From: Lauren Willard [REDACTED]
Sent: 21 June 2021 09:16
To: Zoe Toppin <Zoe.Toppin@arun.gov.uk>
Cc: Lauren Willard [REDACTED] Daniel Vick <Daniel.Vick@arun.gov.uk>; Juan Baeza <Juan.Baeza@arun.gov.uk>
Subject: Re: EP/16/21/PL

Client: Mr D Lynch		
Project Address: The Garage The Way East Preston		
Drawing Title: Existing and Proposed Plans and Elevations		
Drawing Number: 1241.01.g		
Scale:	As stated printed @ A1	
Date:	06/01/2020

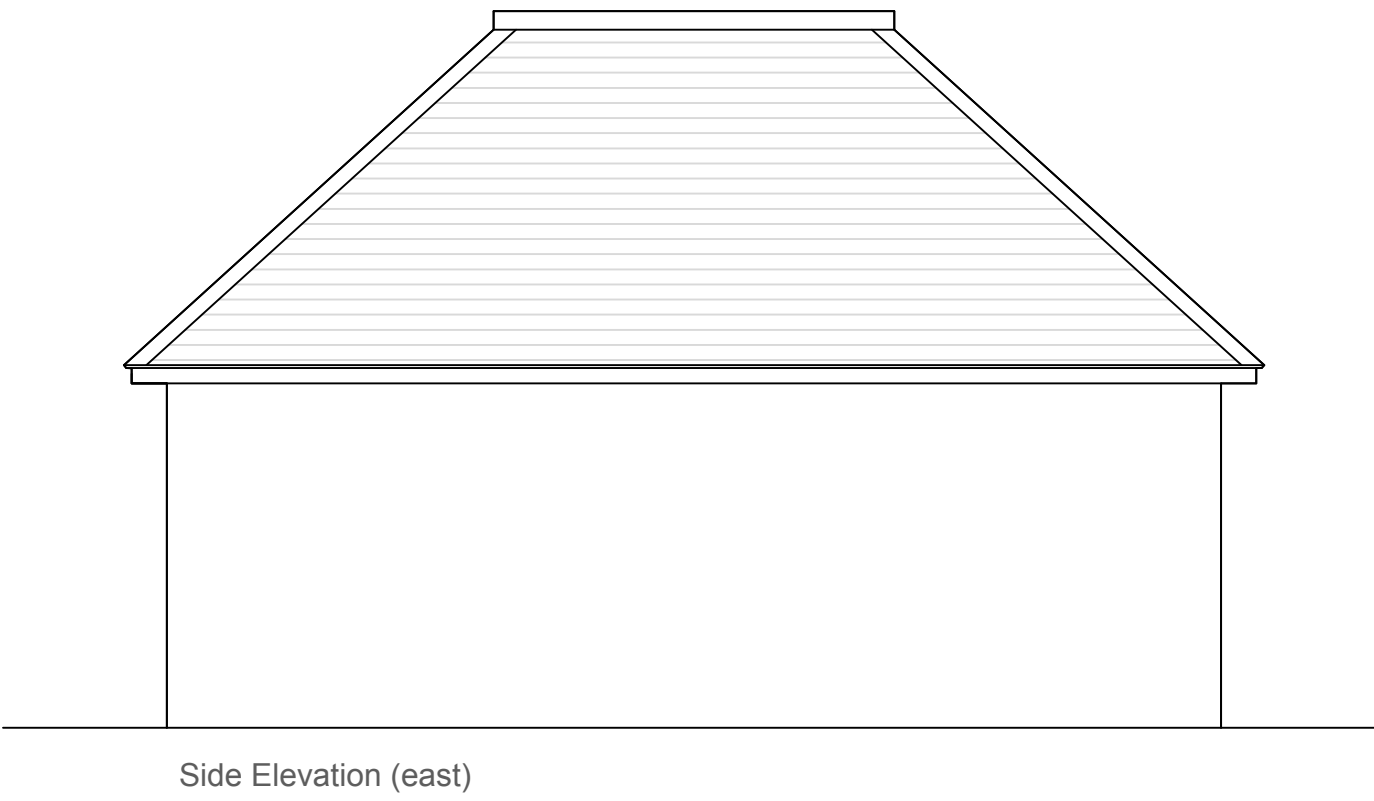
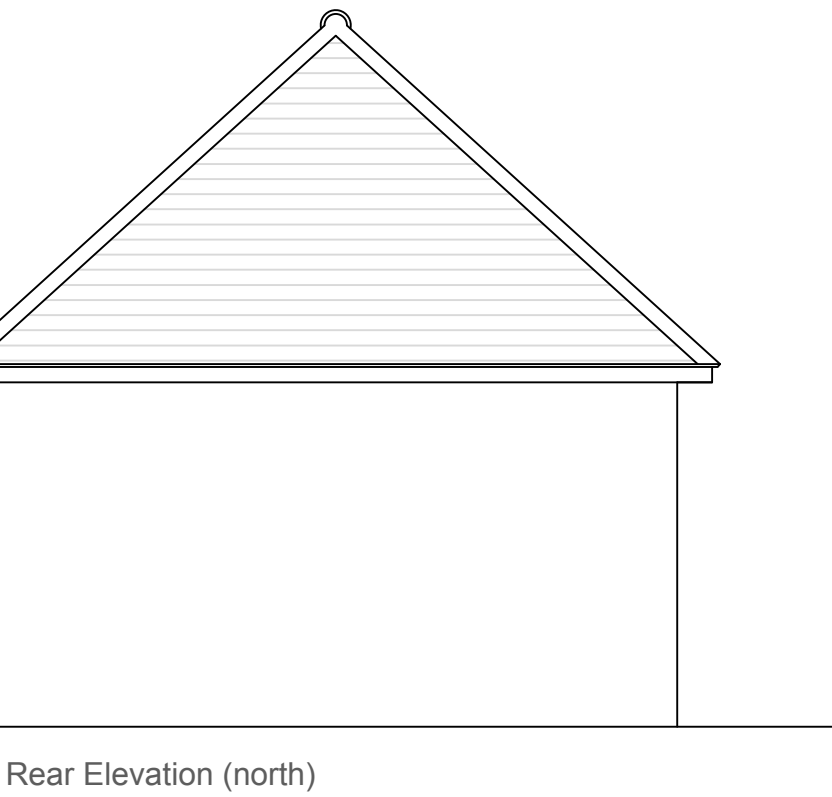
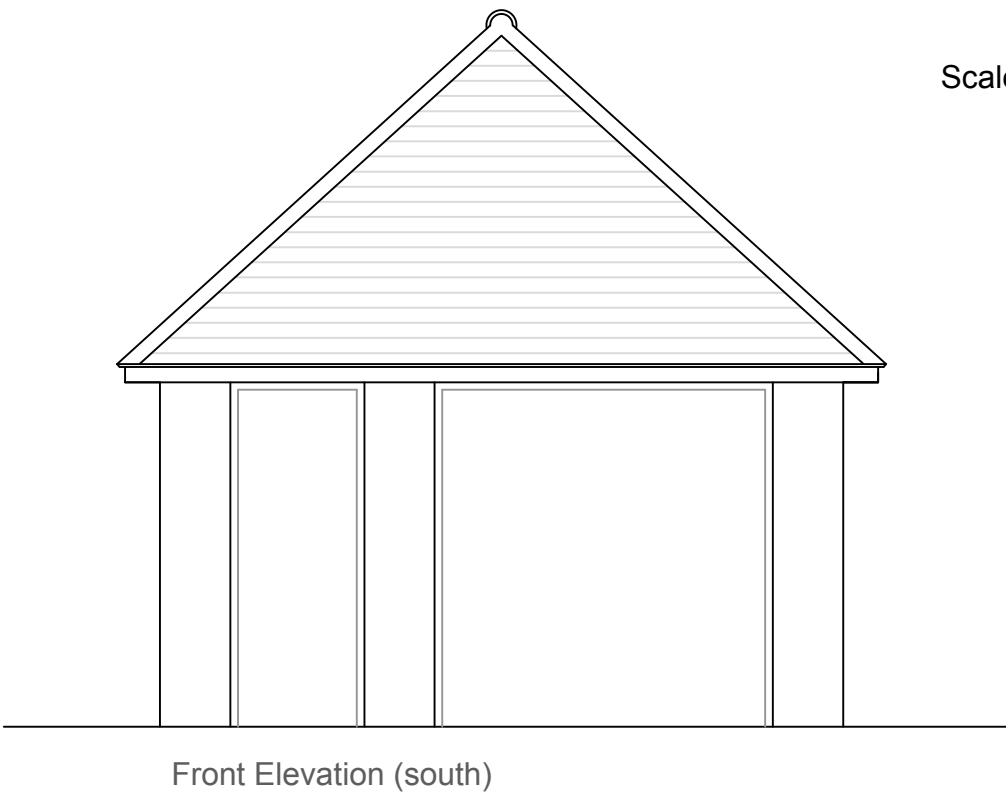
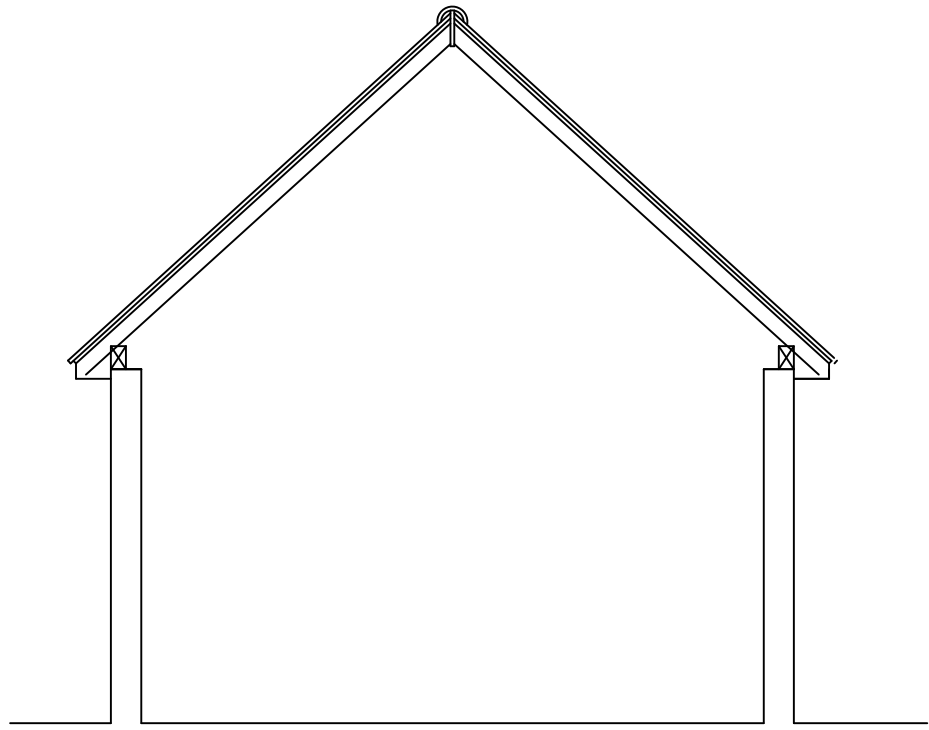
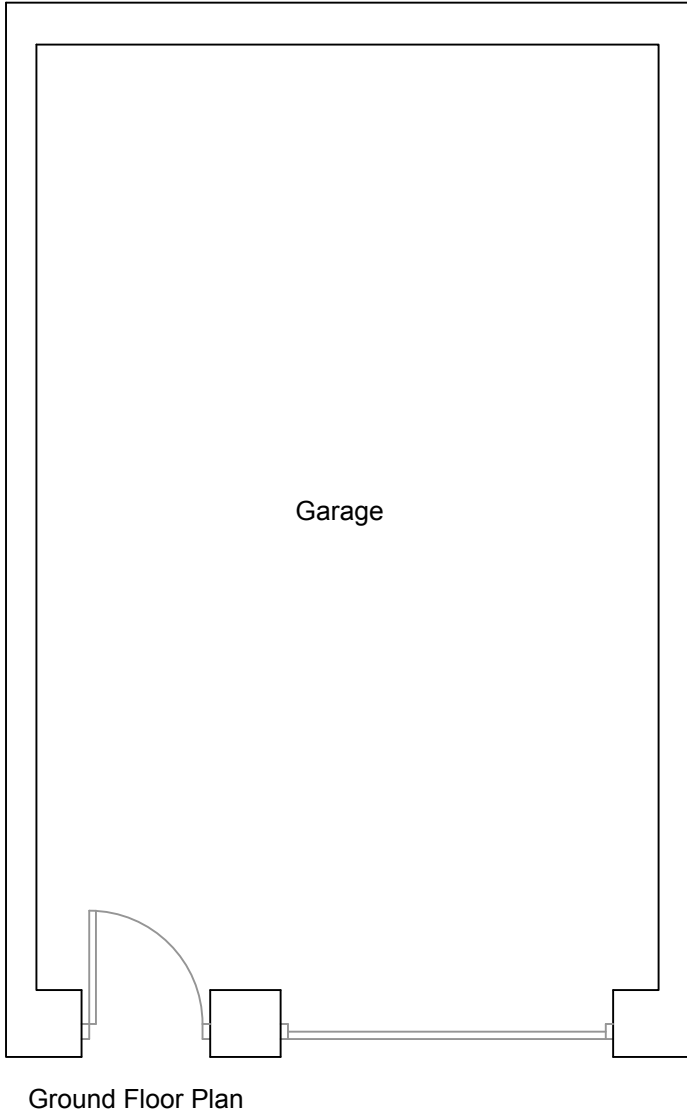
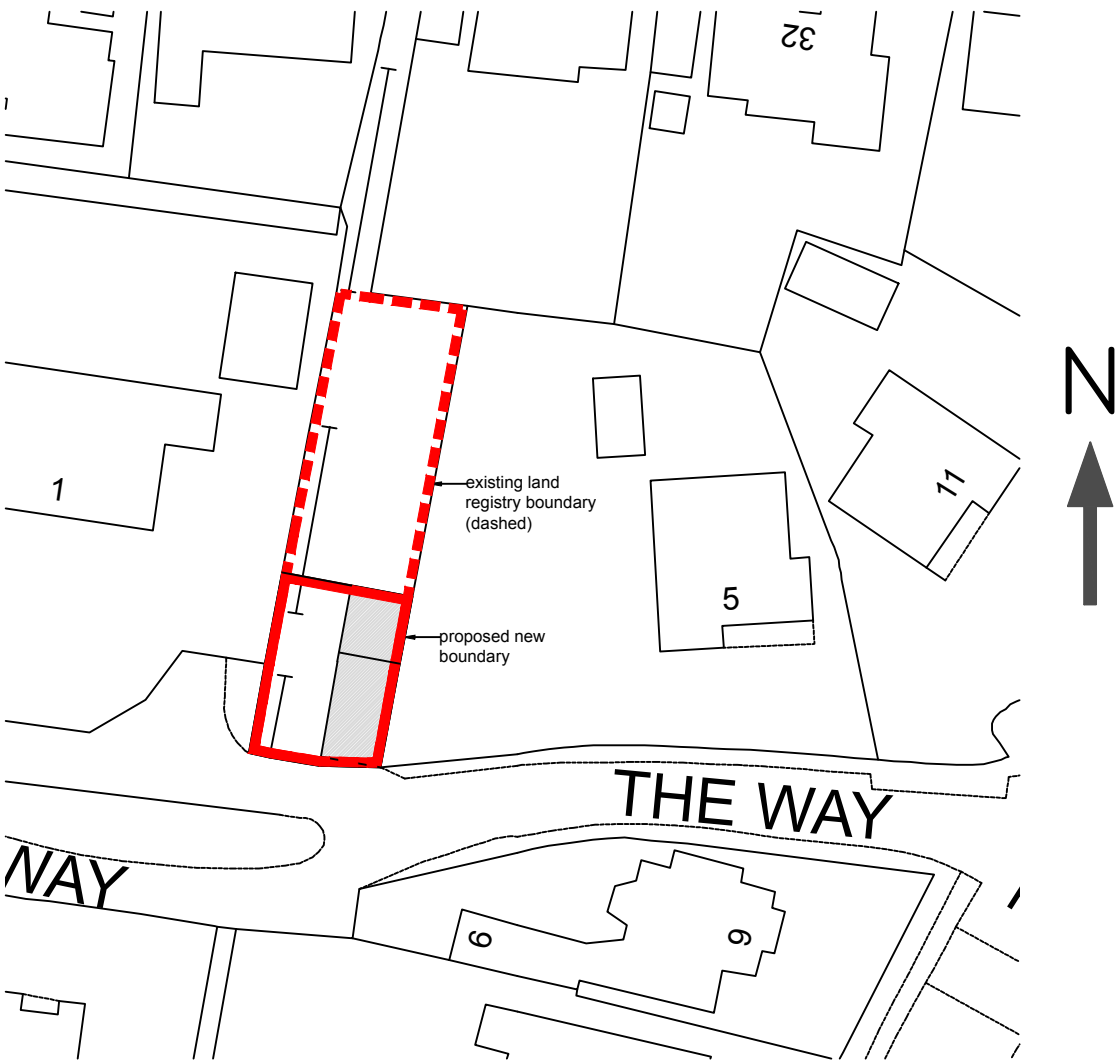
There has been a condition added to this application to show the three windows on the side (east) elevation of the garage will be permanently obscurely glazed and fixed shut up to a height of 1.7m from the finished floor level in order to protect the private amenity to the neighbours at the east. Please can you provide a plan to show this with a cross section from the ground to 1.7m to show the windows will be obscurely glazed and fixed shut up to a height of 1.7m.

There has also been concerns of why a dormer would be necessary for a garage if it is to be used as storage. As a result, it would be necessary to remove the dormer to the garage for this proposal. Please provide amended plans to show the dormer has been removed.

The three windows on west elevation should also be removed from the proposal as the garage will be used for storage there is no necessary need for windows, this will also create amenity issues.

1. An amended plan for the east elevation to show the cross section from the ground to 1.7m to show the windows will be obscurely glazed and fixed shut up to a height

I have removed the dormer and reduced the number of roof lights. I have also reduced the size of the roof lights and positioned them so the cill of the roof lights are 1.7m from finished floor level so there is no overlooking. I have included a section to demonstrate the position of the roof lights.

I have reverted to a hipped roof at the rear of the building which is as per the pre-application advice scheme. I have done this in order to accommodate the staircase and still provide space for the two cars in the garage.
